Our ref: NO/2012/103452/01-L01
Your ref: 3/2011/0824
Date: 26 March 2012

**PROPOSED EARTH WALLED, COVERED SLURRY STORE TO BE BUILT ON A
FORMER COMPOSTING SITE
HAWKSHAW FARM, LONGSIGHT ROAD, CLAYTON-LE-DALE**

Proposed Floor Plan
1cm to 3 metres

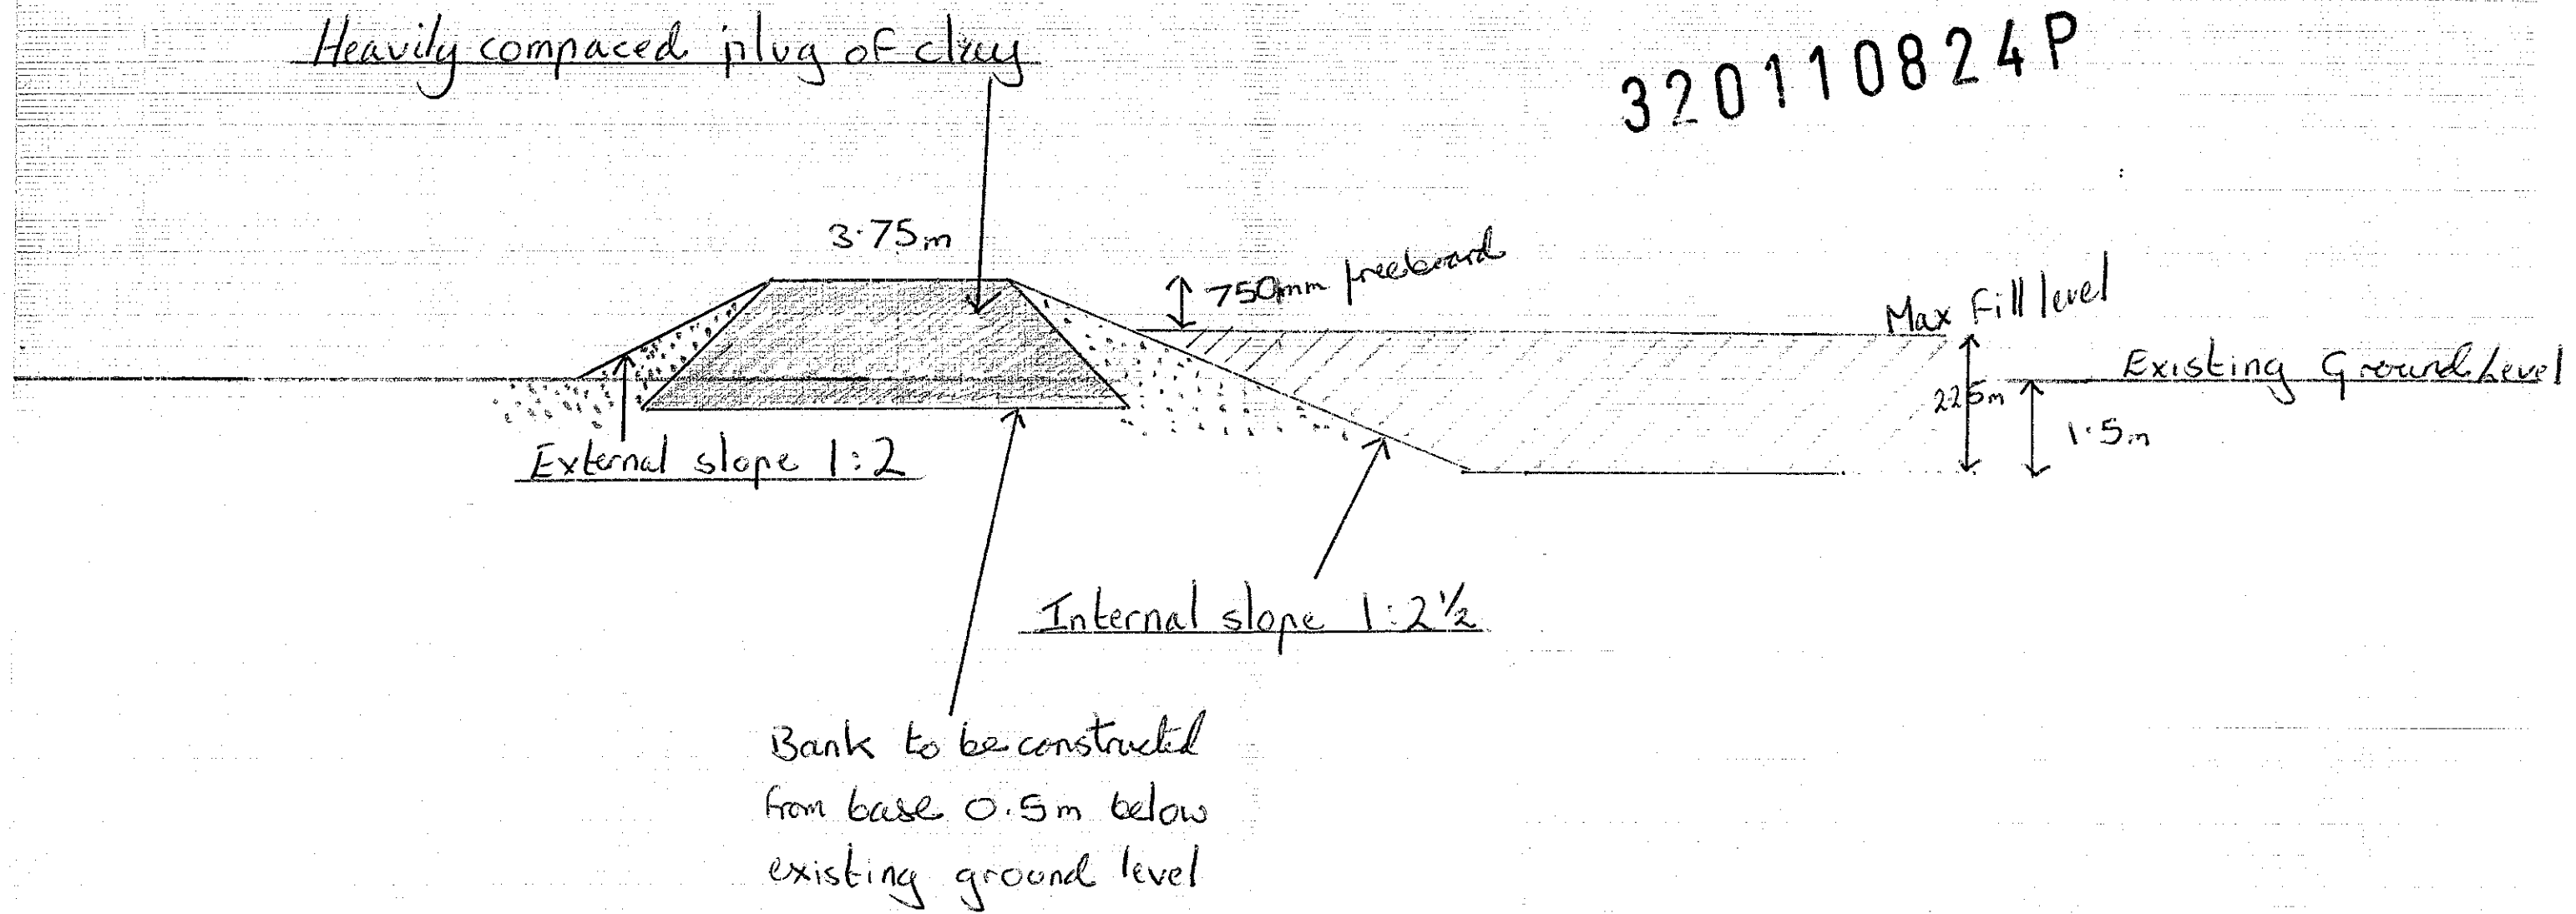
The basic requirement for this type of construction is that there is a lining of at least 1 metre of suitably low permeability deposits beneath the storage area and ideally the water table should be below the level of the proposed base. We have produced a summary sheet outlining the necessary soil characteristics for this type of storage structure based on CIRIA Report 126 (available online at [http://www.environment-agency.gov.uk/static/documents/Business/Soil testing for earth bank lagoons.pdf](http://www.environment-agency.gov.uk/static/documents/Business/Soil%20testing%20for%20earth%20bank%20lagoons.pdf))

The application is not accompanied by the calculations verifying the capacity required for the lagoon. The site produces a large volume of dirty surface water which will need to be taken into account in constructing a lagoon that is adequately sized. Given this, while the SSAFO regulations identify a minimum storage capacity of 4 months, we would urge the applicant to consider a capacity of 6 months or more in this instance. Calculations demonstrating the capacity of the lagoon should be submitted to us.

The window for this year's Catchment Sensitive Farming grant applications closes at the end of April. If the applicant has not yet submitted a grant application for the proposed floating cover, they should do so. We would definitely want to see this lagoon covered and it is better if the cover is fitted whilst the lagoon is empty rather than fitted retrospectively.
